Ribble Valley Borough Council
Council Offices
Church Walk,
Clitheroe
Lancashire
BB7 2RA

Phone: 0300 123 6780
Email: developeras@lancashire.gov.uk
Your ref: 3/2026/0315
Our ref: 3/2026/0315/HDC/KW
Date: 22 July 2026

Location: Land off Chatburn Road Clitheroe BB7 4JX
Proposal: Residential development of 39 dwellings with associated landscaping, car parking and access.
Grid Ref: 375365 443101

Proposed Site Layout

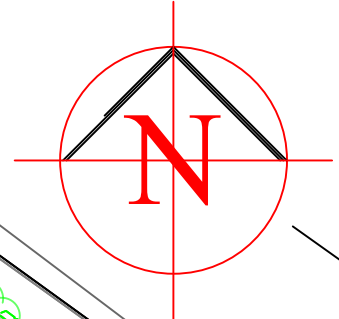
The LHA has reviewed the proposed internal layout as shown on the submitted Proposed Site Layout drawing number 067/P/01. The development is arranged around a loop road with a number of short private drives and shared access drives serving small groups of dwellings. Overall, the road layout provides good connectivity throughout the site. However, the LHA would look for the shared access road design fronting plots 32 – 39 to form a continuous formal carriageway design creating a clearly defined primary loop road around the site. The overall width of the carriageways around the site should also be reviewed and amended where necessary; two-way residential streets should typically have 5.5m wide carriageways. A spot check of carriageway widths found that the site is mostly made up of carriageway widths of approximately 5m.

Plots 29 – 31 are accessed via a private shared access road layout, which mostly measures 4.8m in width, which is acceptable for a shared access road, however it does reduce slightly outside plot 30, this should be amended to ensure the entire width remains at least 4.8m wide.

The submitted layout generally provides good forward visibility along the internal road network. The primary route incorporates relatively gentle bends which should achieve appropriate forward visibility for the anticipated 20mph design speed. However, detailed visibility information has not been provided for internal junctions as part of the submitted layout. Any parking spaces, landscaping features or street furniture should be located outside of required visibility envelopes such as the parking provisions at plot 28, which has two trees that fall within the visibility splay envelope.

Whilst 2m wide footway provisions have been provided on both sides of the access, the rest of the site does not benefit from the same provisions. With 1.8m footway provisions being provided along one side of the carriageway between plots 1 – 21, the rest of the site lacks segregated provisions. Footway provisions across the site also do not appear to provide a continuous width of 2m to be in line with inclusive mobility guidance. The LHA would seek that continuous 2m wide footway provision is provided along both sides of the carriageway, particularly fronting dwellings, such as between plots 1 – 9 and the absence of footway provisions fronting plots 22-28. Whilst shorter private access roads, such as the road fronting plots 29 – 31 are acceptable to rely upon shared vehicle and pedestrian areas, footway continuity should be reviewed around turning heads and ensure pedestrian desire lines are maintained.

Examples of where further pedestrian access should be considered are areas where driveways are bound with neighbouring properties' driveways, such as plots 24 and 25, as well as plots 18 and 19. Areas such as this can result in access conflict between neighbours relying on third-party land to provide additional width for doors opening and

- Redesign the shared access road serving Plots 32–39 as a continuous formal carriageway to create a clearly defined primary loop road.
- Review and increase carriageway widths where necessary; main two-way residential streets should generally be 5.5m wide.

- Maintain a minimum 4.8m width along the entire shared access road serving Plots 29–31, including outside Plot 30.
- Provide footway provisions on Ridding Close to support increased pedestrian and cycle use.

- Remove or relocate any parking or landscaping that obstruct required visibility splays
- Provide continuous 2m-wide footways throughout the development

- Provide a separation between driveways serving separate plots
- Review parking layouts to ensure spaces are appropriate and in line with the Joint Lancashire Structure Plan
